Planning Statement

20 Westholme Gardens, Ruislip, HA4 8QJ

This Planning Statement has been prepared in support of a householder planning application at 20 Westholme Gardens, Ruislip, HA4 8QJ.

FRONT ELEVATION

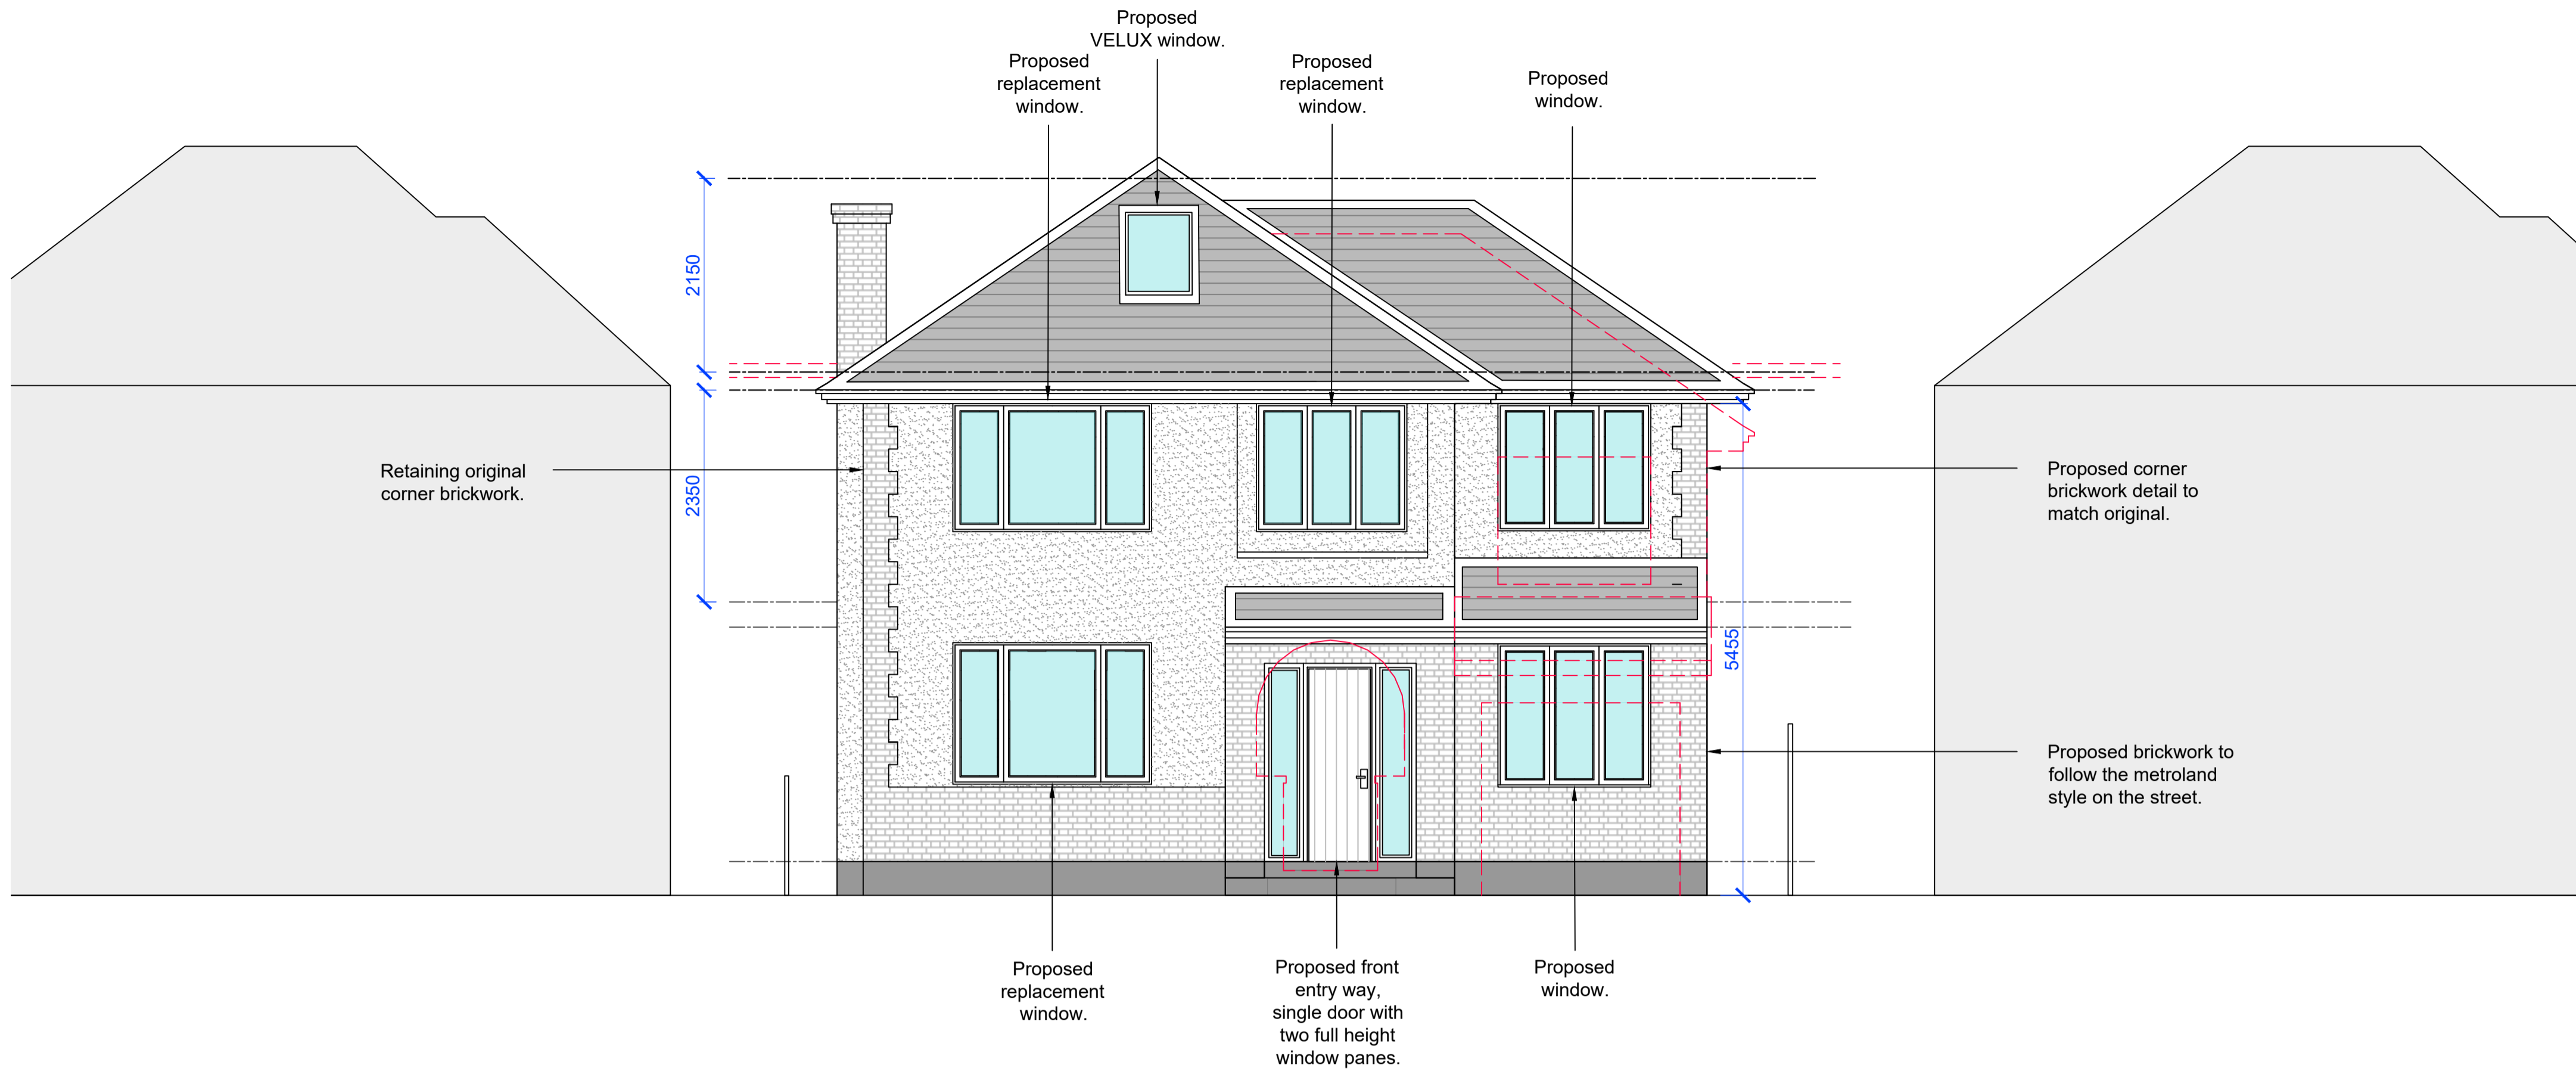
The pre-application advice recommended that some exposed brickwork be retained to the front elevation, either through a brickwork band at ground floor level or by retaining or expanding the existing brick quoining pattern. The officer considered that this would help preserve visual interest and better reflect the established Metroland character of the area.

The current proposal has been amended to incorporate brickwork detailing to the front elevation. This responds directly to the officer's comments and ensures that the revised frontage retains visual interest, relates appropriately to the original dwelling, and sits comfortably within the wider street scene.

SIDE ELEVATION

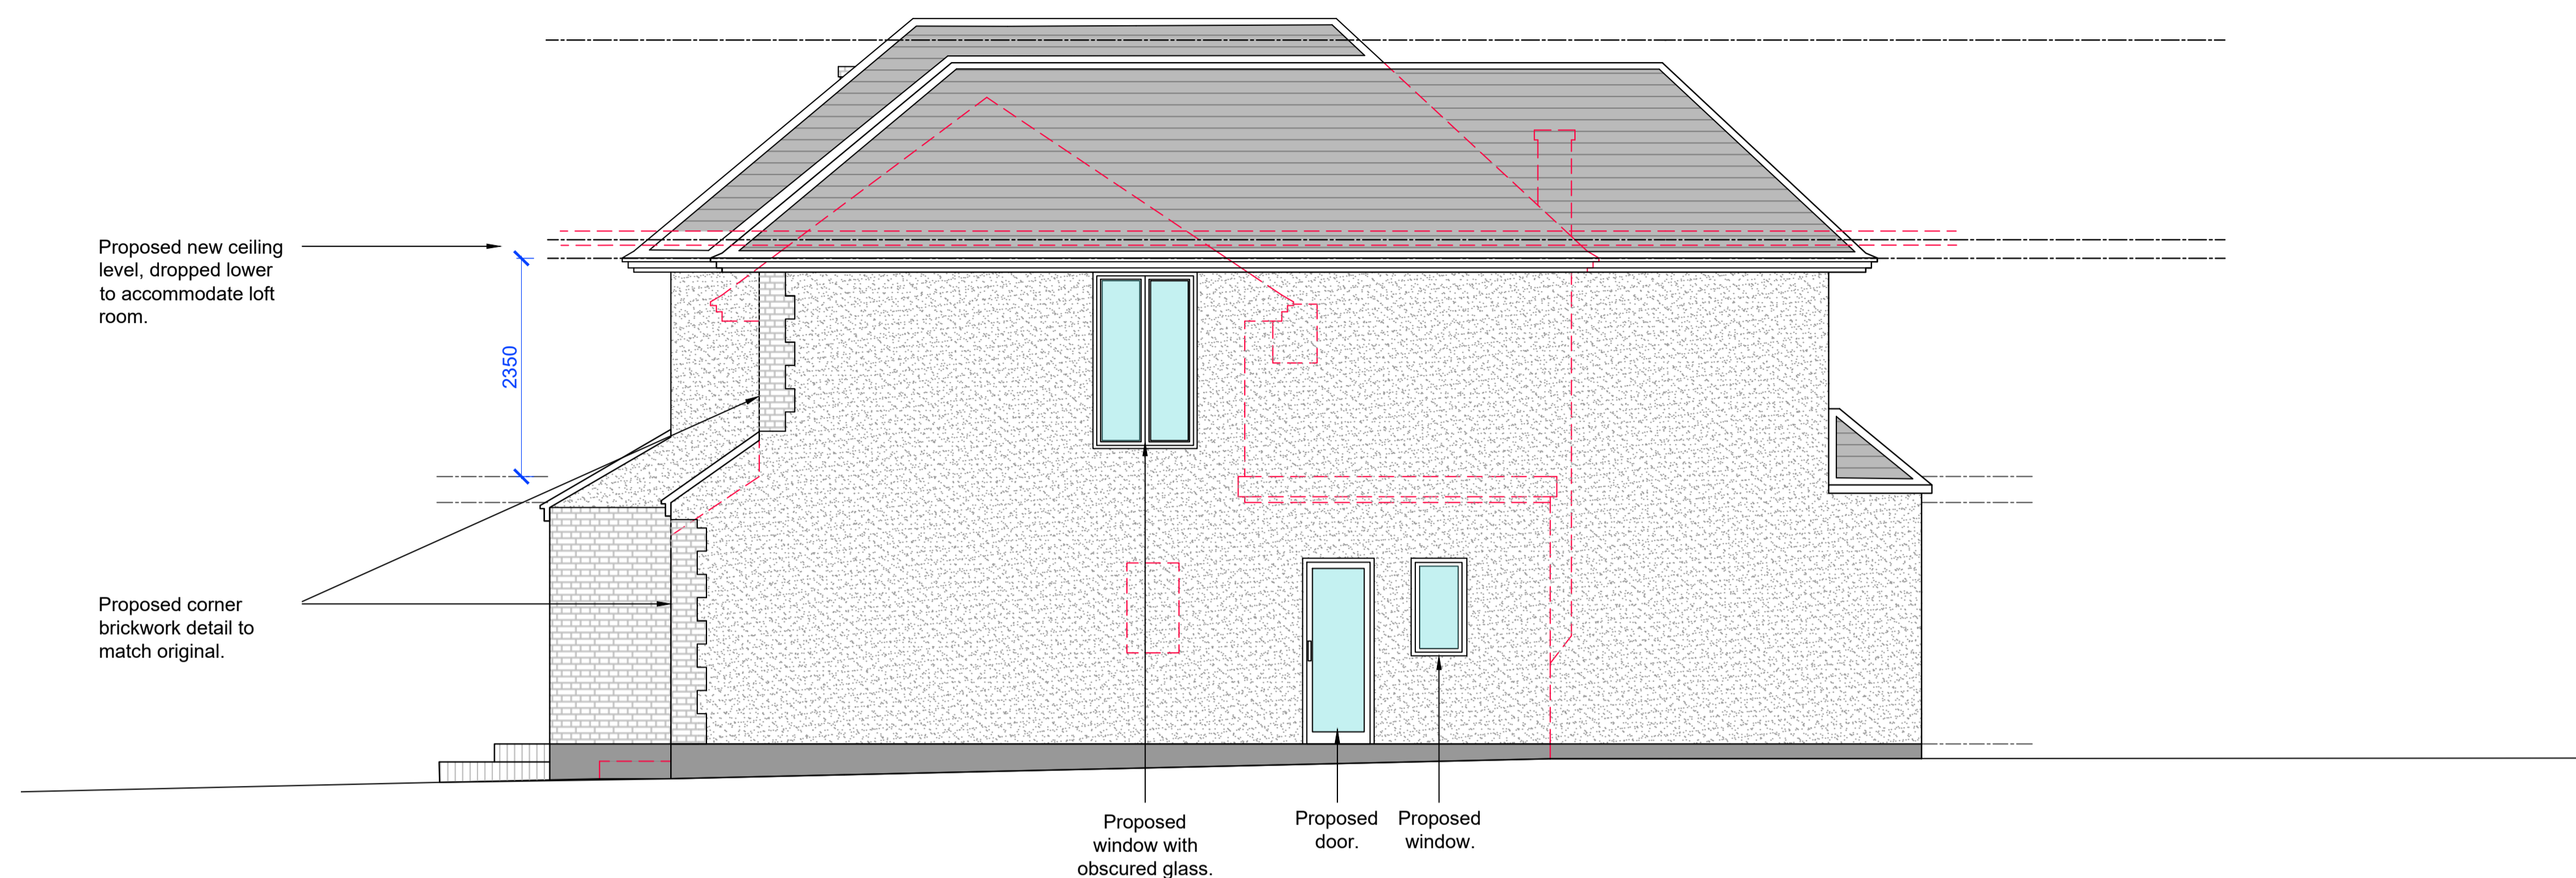
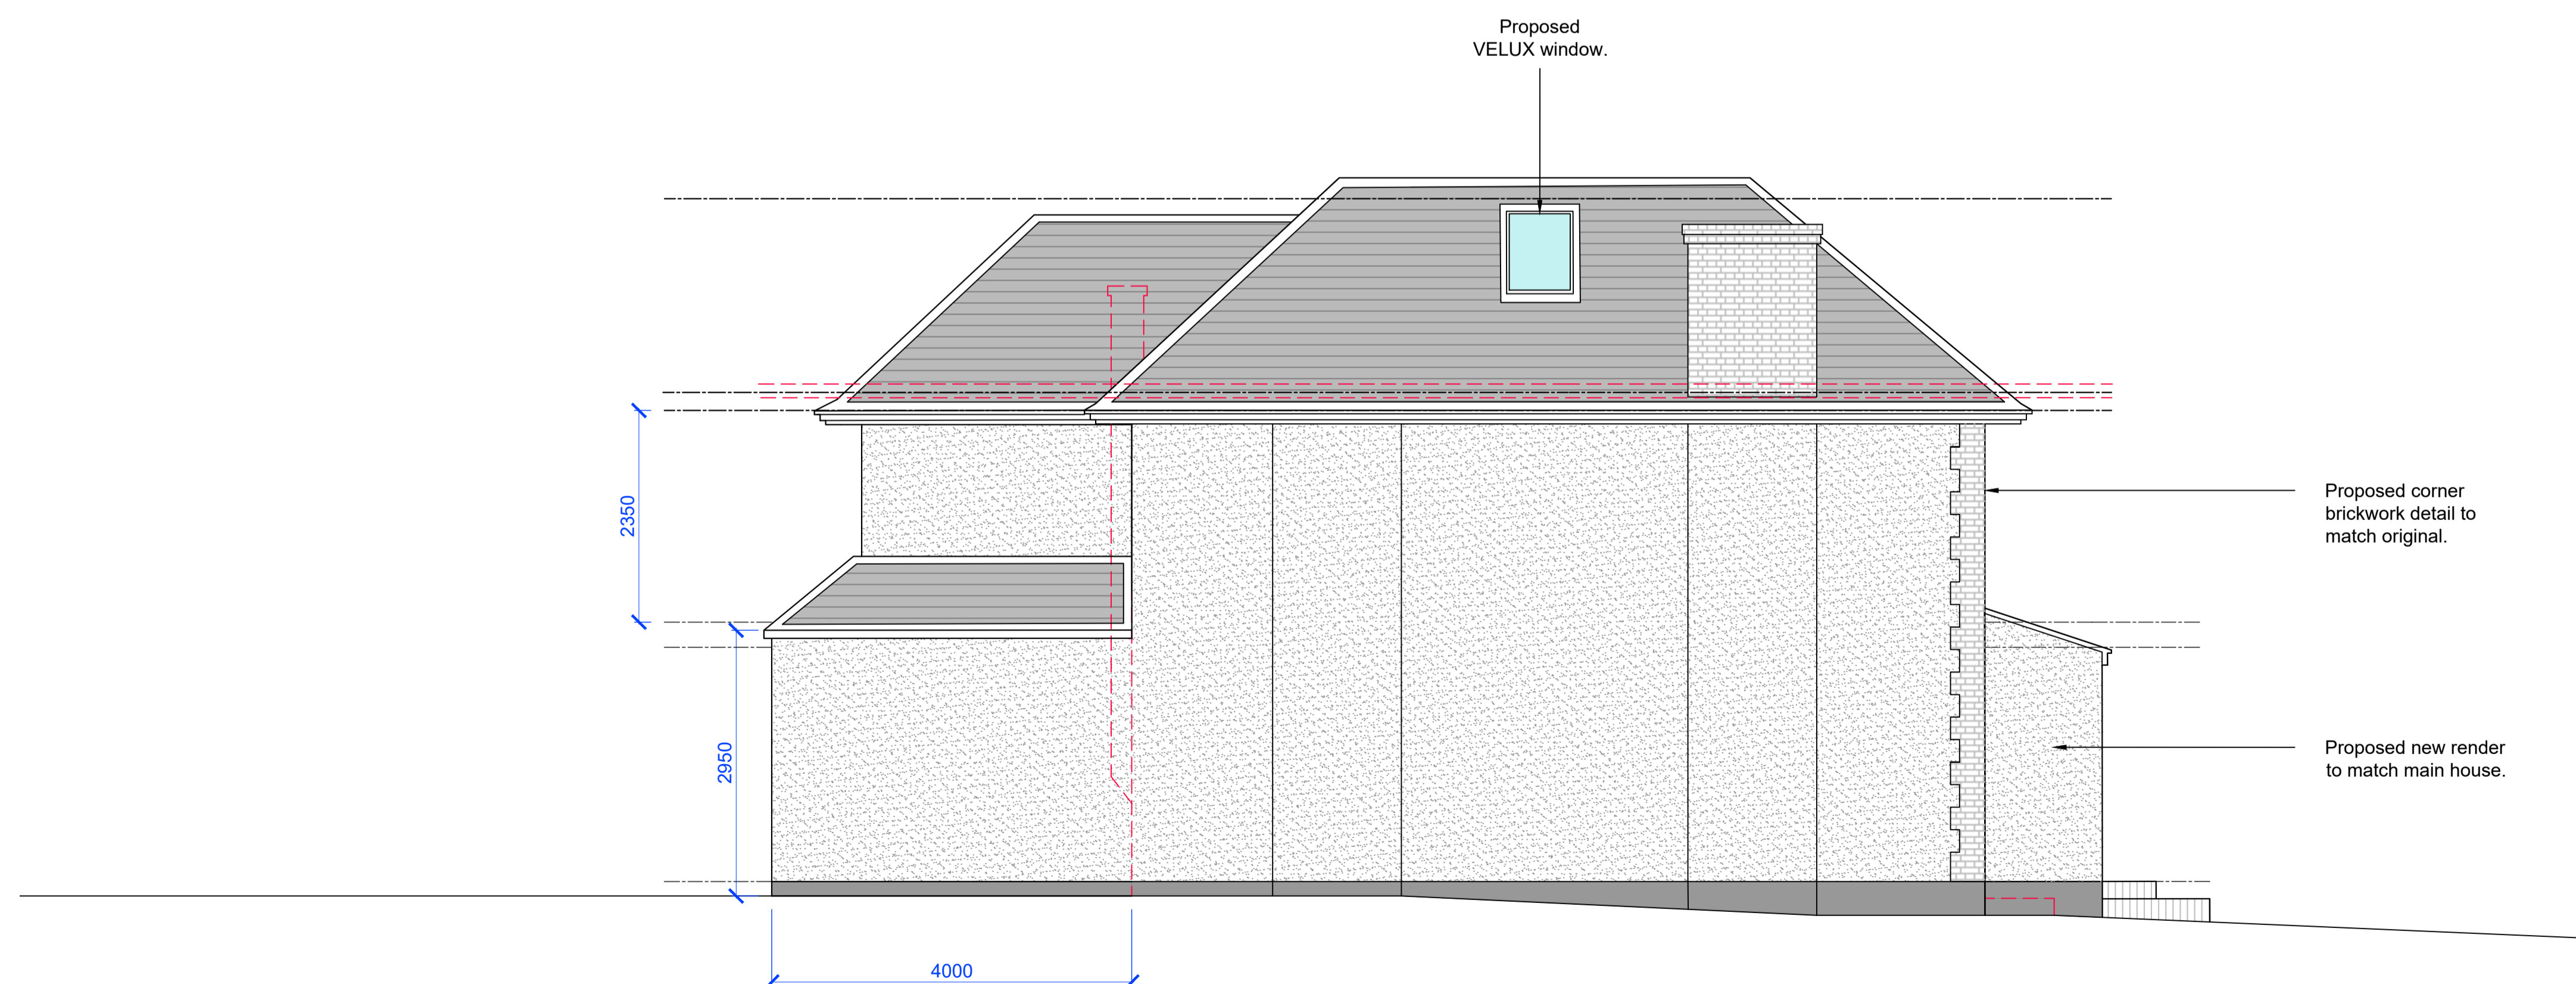
The pre-application scheme included a single-storey rear extension with a depth of approximately 6 metres and a height of approximately 3.47 metres. The Council advised that this should be reduced to a depth of 4 metres and a height of 3 metres to better accord with Policy DMHD 1.

The pre-application advice identified potential amenity concerns for No. 22 Westholme Gardens, particularly in relation to overshadowing from the previously deeper and higher single-storey rear extension.

The submitted proposal has been amended accordingly. The proposed floor plan and side elevation now show the rear extension reduced to a depth of 4 metres, with a reduced height to sit more comfortably with the host dwelling and neighbouring properties. This directly addresses the officer's concern regarding the scale of the rear projection.

The revised scheme addresses this by reducing the depth of the single-storey rear element to 4 metres and lowering its overall height. This materially reduces the potential for overshadowing and overbearing impact. The proposed relationship with No. 18 Westholme Gardens remains acceptable, particularly given the angled relationship between the properties, as identified by the Council in the pre-application advice.
